Date: 2022.06.12

RE: Commentary Response per Permit No. 2112-250

This letter is in regards to your INITIAL review of the proposed single-family residence. Please see below for a response to your commentary in *italics* and our responses in **bold**. Thank you.

**A11**

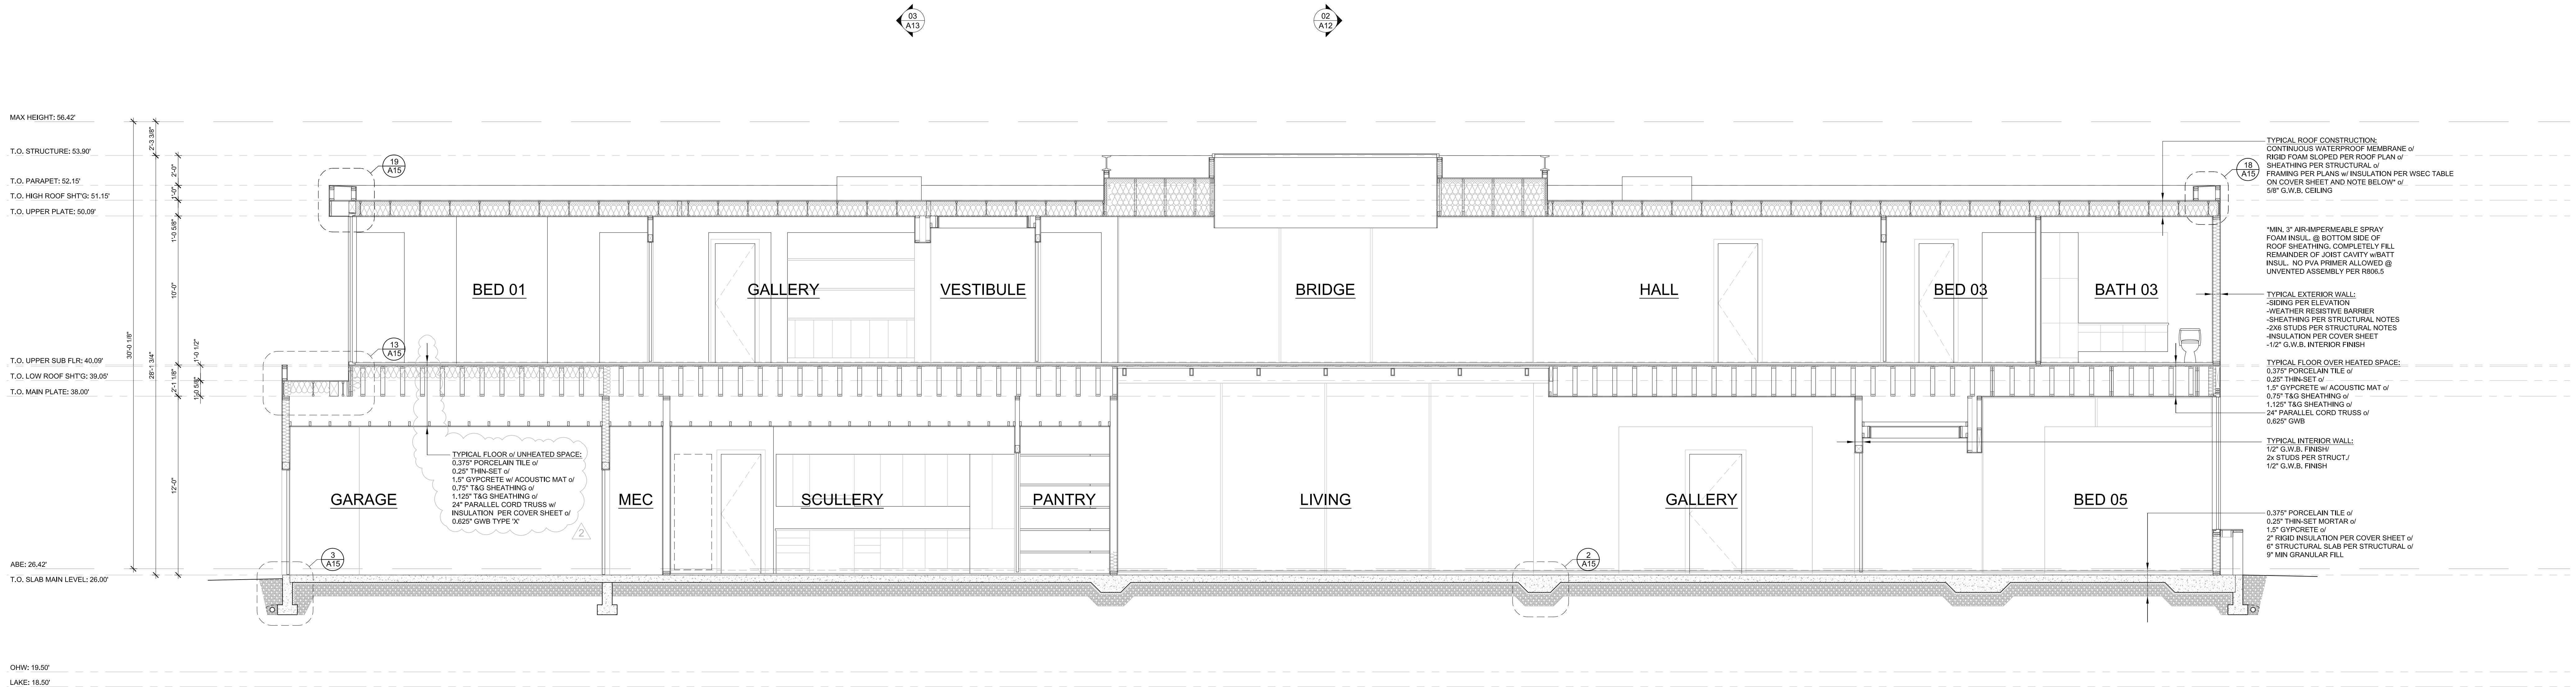
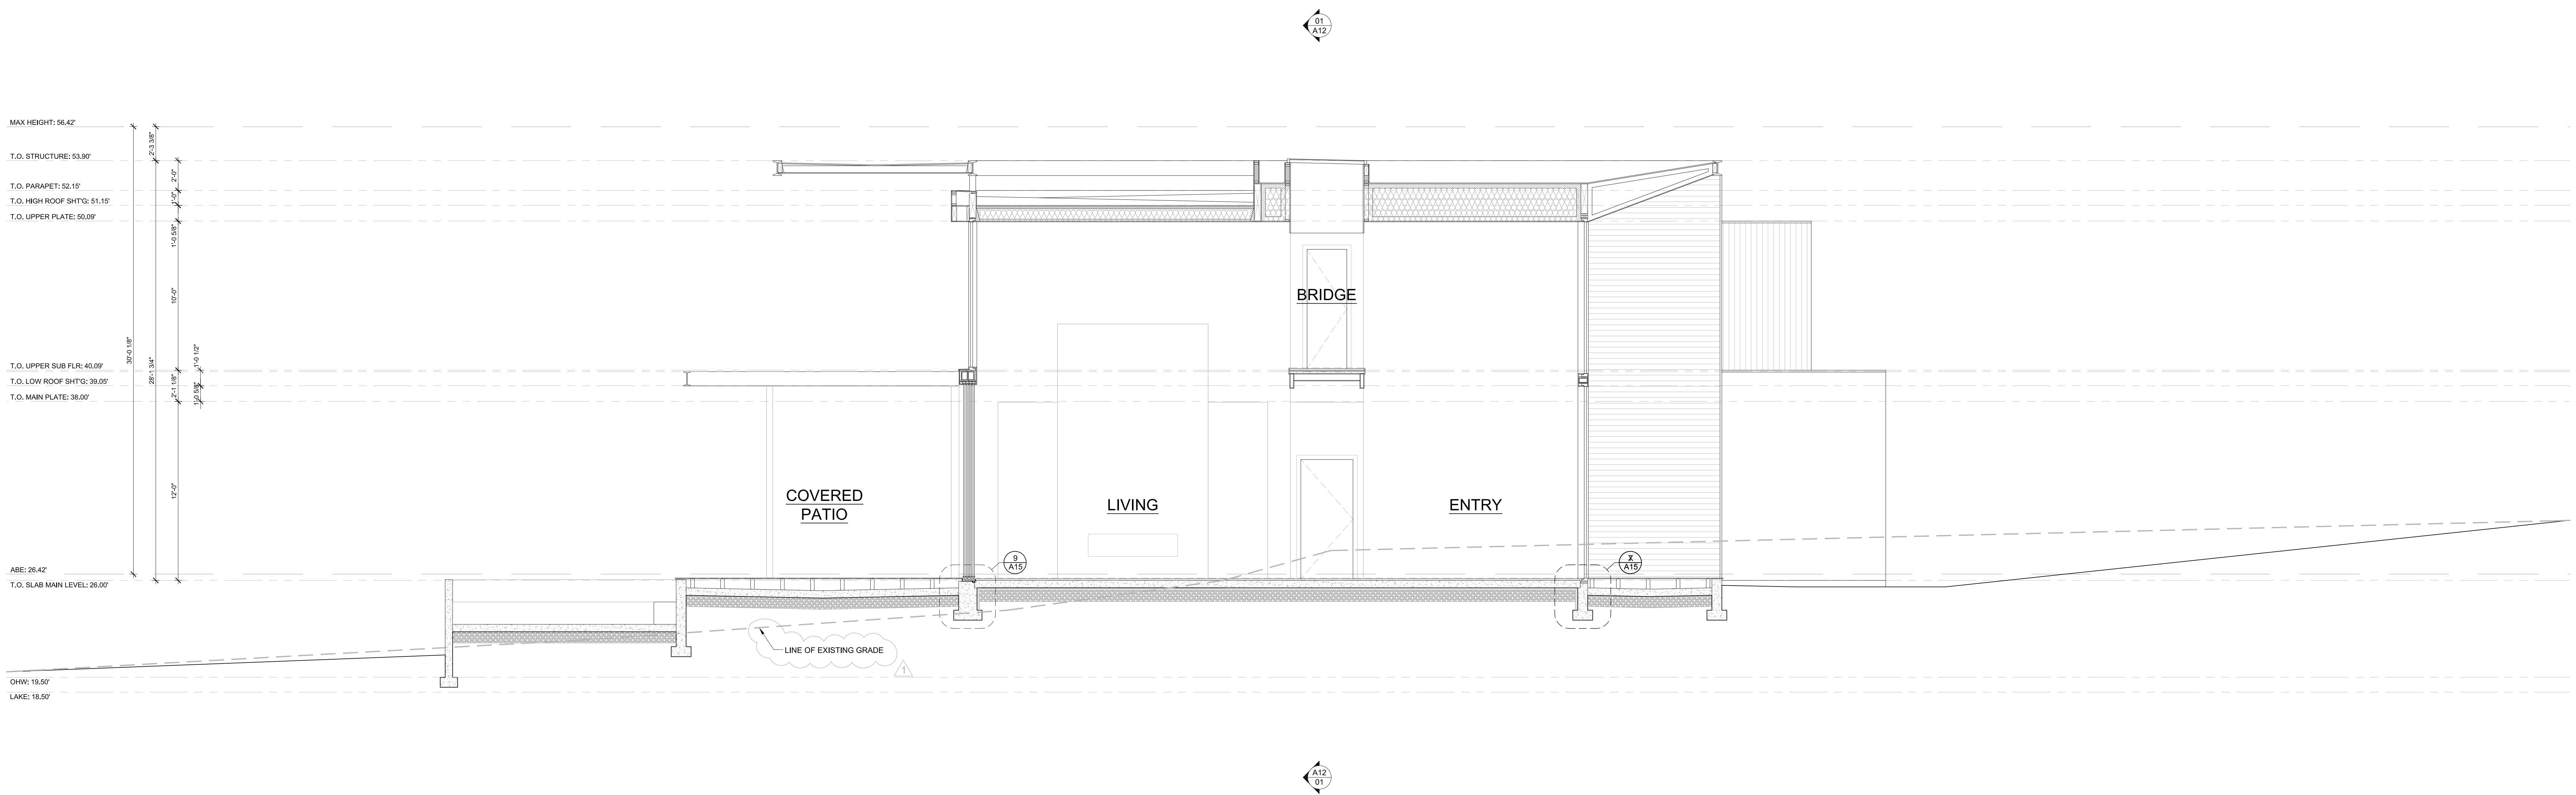
- a. **Note added to plans**
3. *Due to the location of the high groundwater table as described in the geotechnical report, existing grade needs to be clearly depicted on the site sections. Additionally, specify elevation of the pool slab as the bottom of the pool must be above the groundwater table per page 5 of the geotechnical report.*

- a. **Existing grade shown on elevations and building sections. Pool slab elevation noted as well.**
4. *The geotechnical engineer recommends an underslab drainage system be installed beneath the lowest finished floor consisting of at least 9 inches of clean gravel or rock beneath the entire slab footprint with perforated, 4" diameter PVC pipe embedded in the gravel/rock layer at a 15' to 20' spacing and the gravel layer and piping should then be covered with a vapor retarder. We do not find this incorporated into the design. Please coordinate with geotechnical recommendations; see page 12 and Plate 9 of the geotechnical report.*

**TYP - SLAB ON GRADE FLOOR ASSEMBLY**  
SCALE: 3/4\"/>

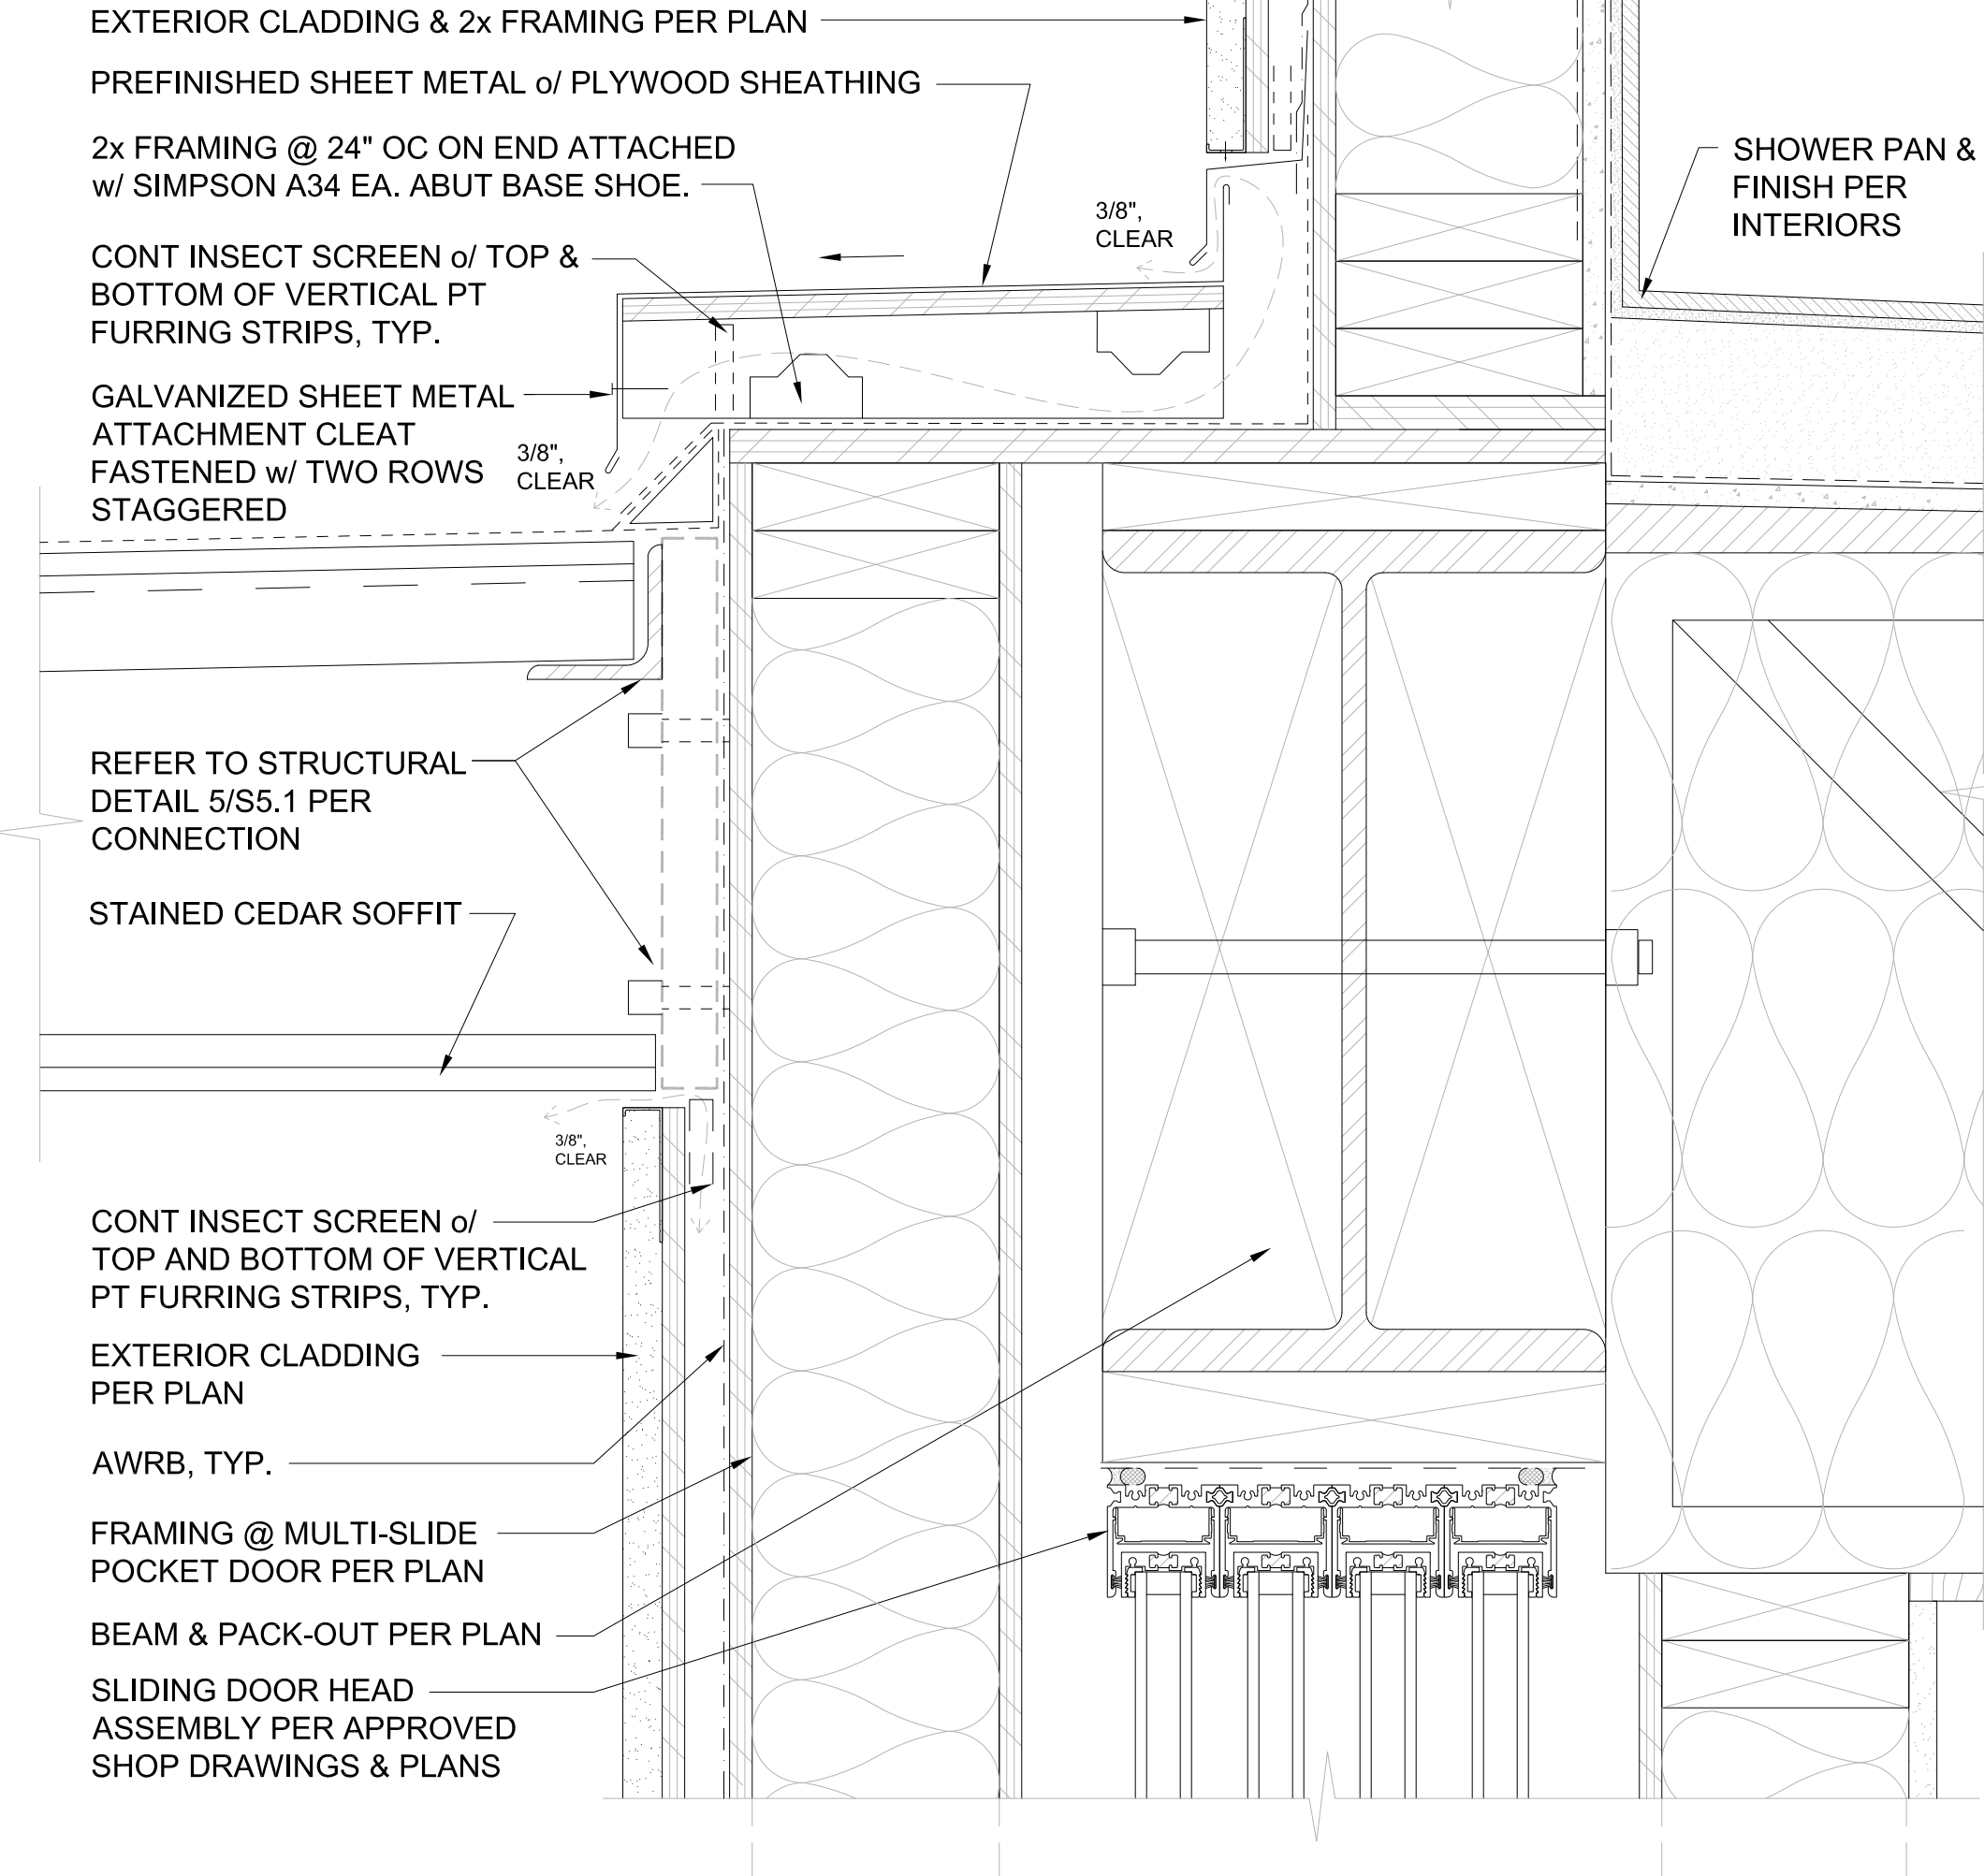
- a. **Cover Sheet and details revised to note no PVA paint on the ceiling.**
6. *Slab-on-grade insulation shall extend downward from the top of the slab before continuing horizontally per WSEC R402.2.9. A two-inch by two-inch (maximum) pressure treated nailer may be placed at the finished floor elevation for attachment of interior finish materials. Please update details on Sheet A15.*

- a. **Details revised to indicate insulation to extend downwards. Due to the structural requirements that the Structurally Reinforced SoG be tied to the stem walls and pin piles, the ability to internally extend the insulation up the stem wall to the top of concrete will not be achievable. In lieu, insulation will turn down the interior side of the stem and an additional layer of insulation will be applied to the exterior of the stem wall from top of footing to an appropriate height to allow for sufficient waterproofing and exterior cladding.**
